Application for a non-material amendment following a grant of planning permission.

Resubmission of planning application relating to design amendments to planning permission 3/2017/0674 in connection with the construction of four dwellings including associated drives, gardens and external landscaping works

Reference number:	<input type="text" value="3/2018/0344"/>
Date of decision	<input type="text" value="24/05/2018"/>

**5513 - P02E**

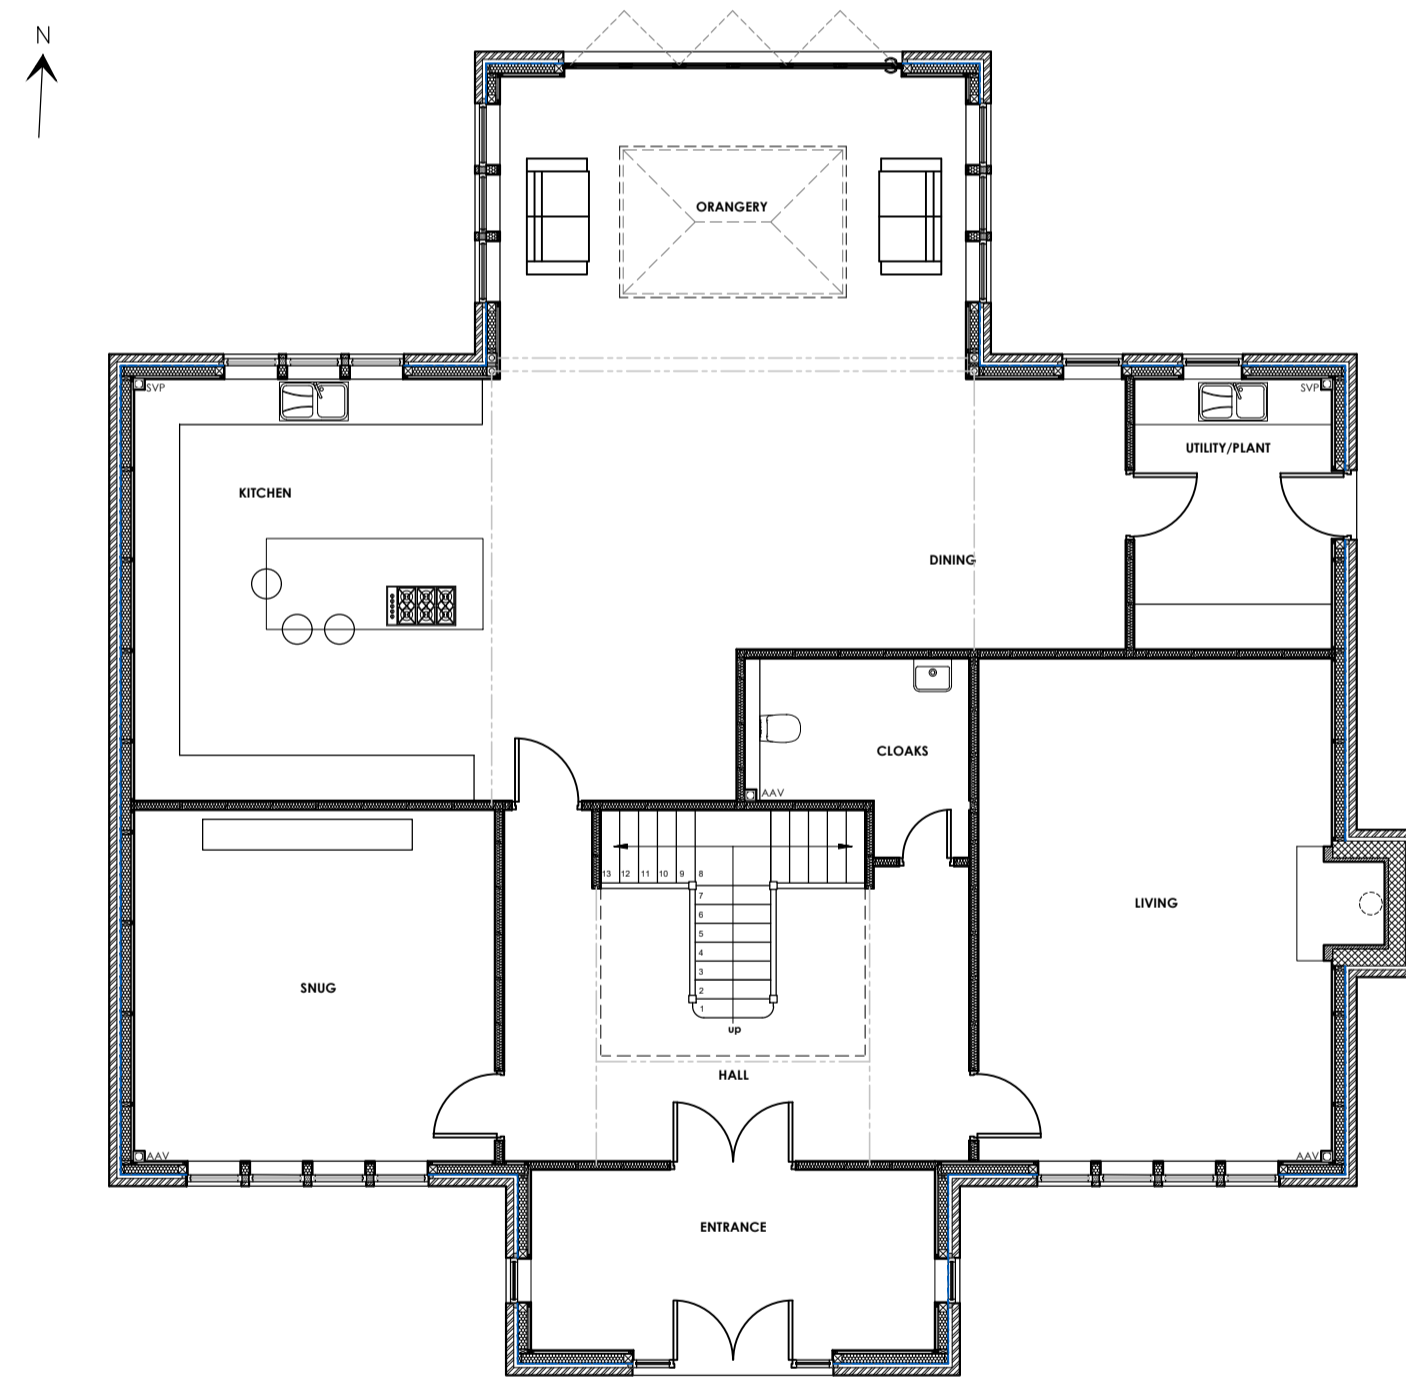
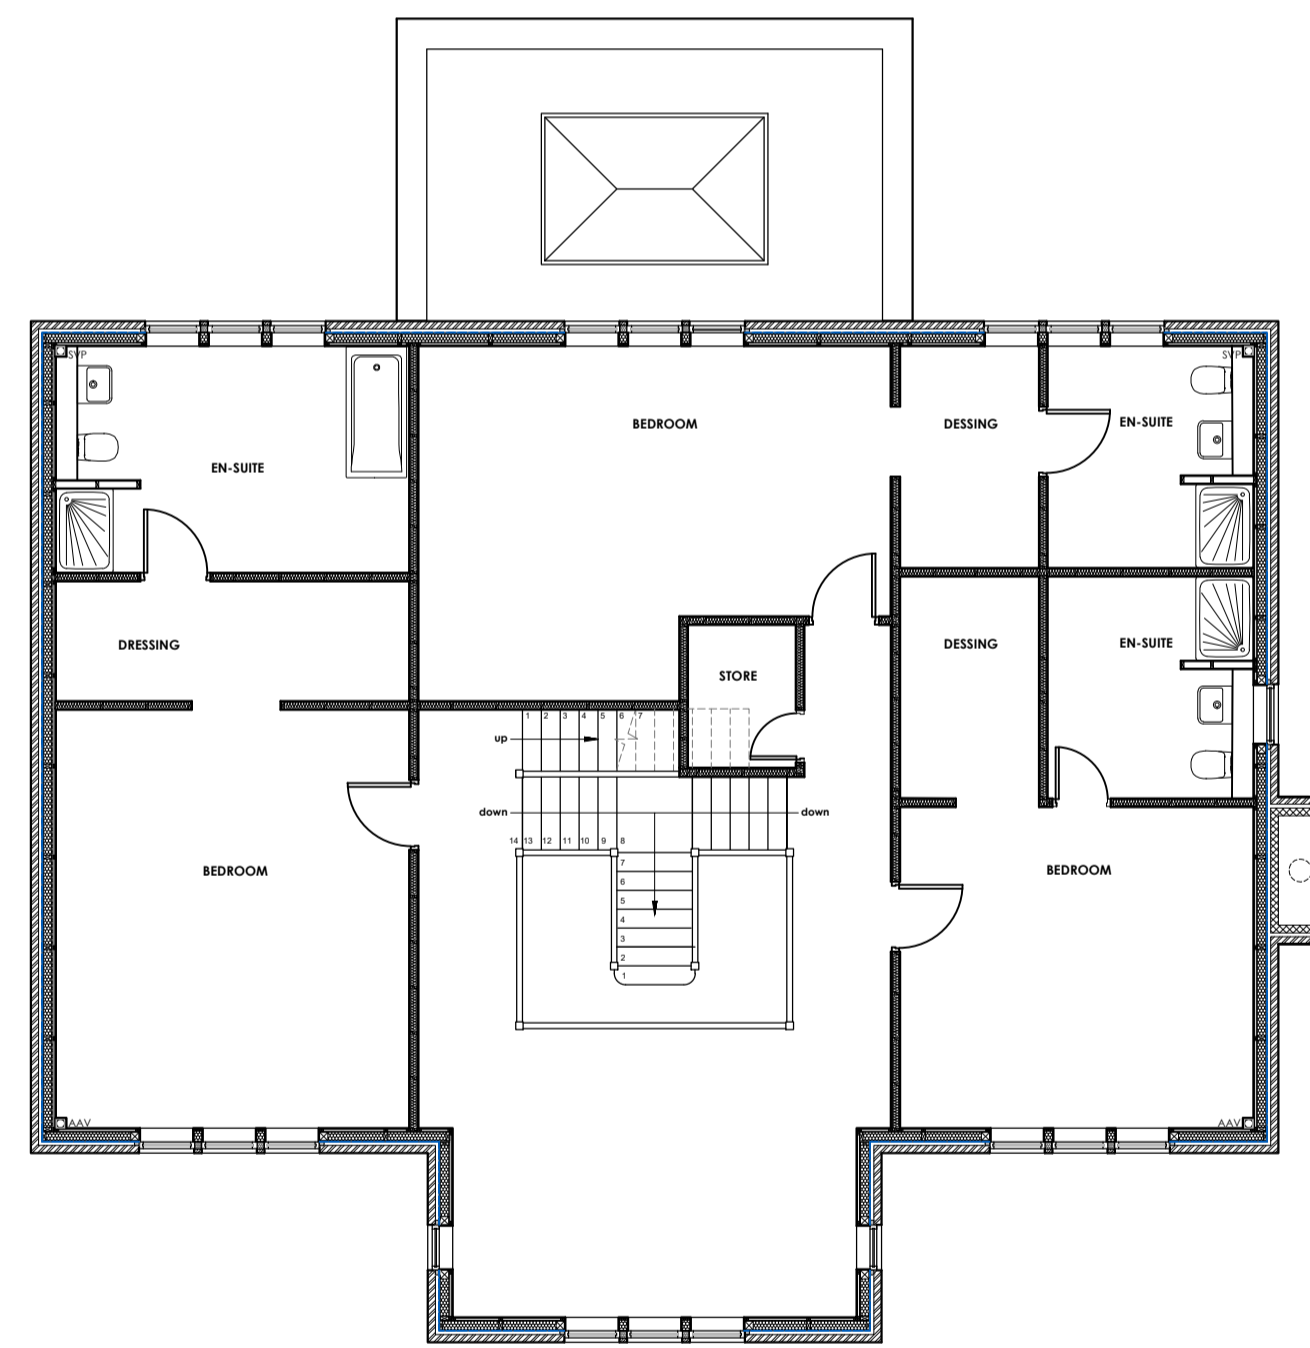
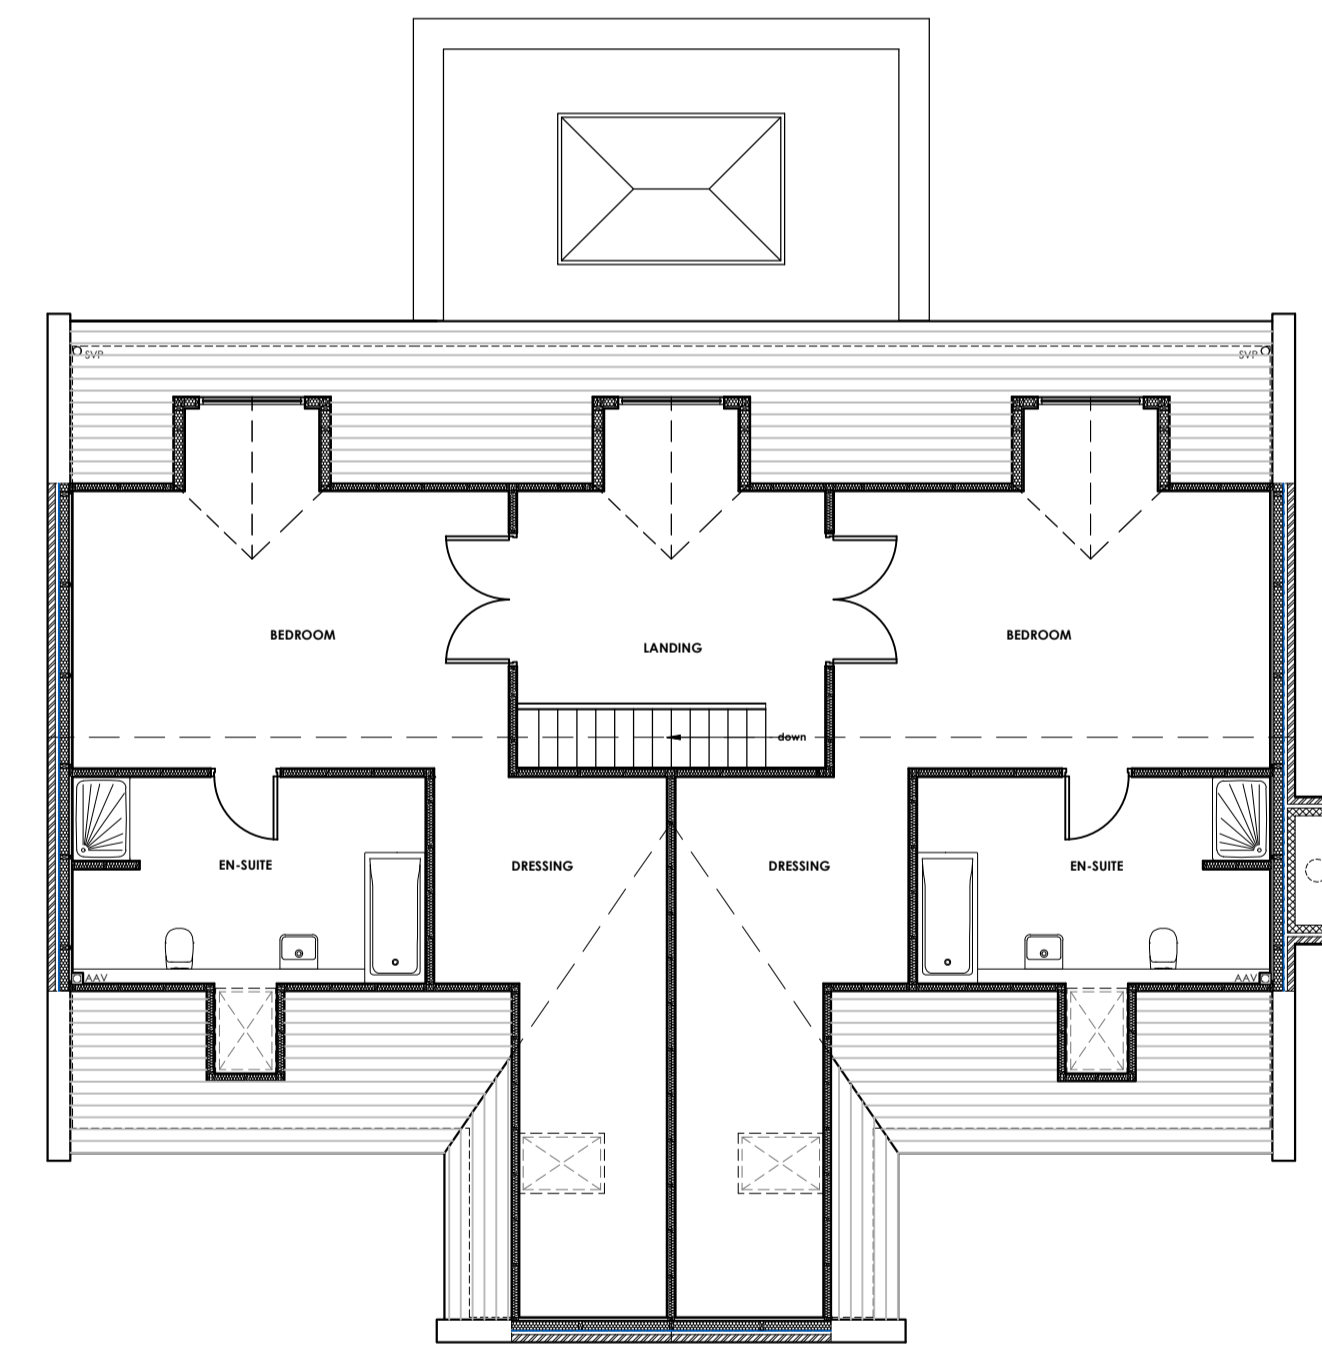
Plot 1: Window added to the east elevation, chimney altered, rooflight positions altered and garage roof height altered.
Plot 2: Central dormer added to the north elevation, chimney altered, rooflights added to the east and west elevation and rooflight positions altered.
Plot 3: Central dormer added to the north elevation, chimney altered and relocated to the east elevation, door relocated to the east elevation, rooflights added to the east and west elevations, rooflight positions altered, additional skylight added to the orangery and ground floor layout revised.
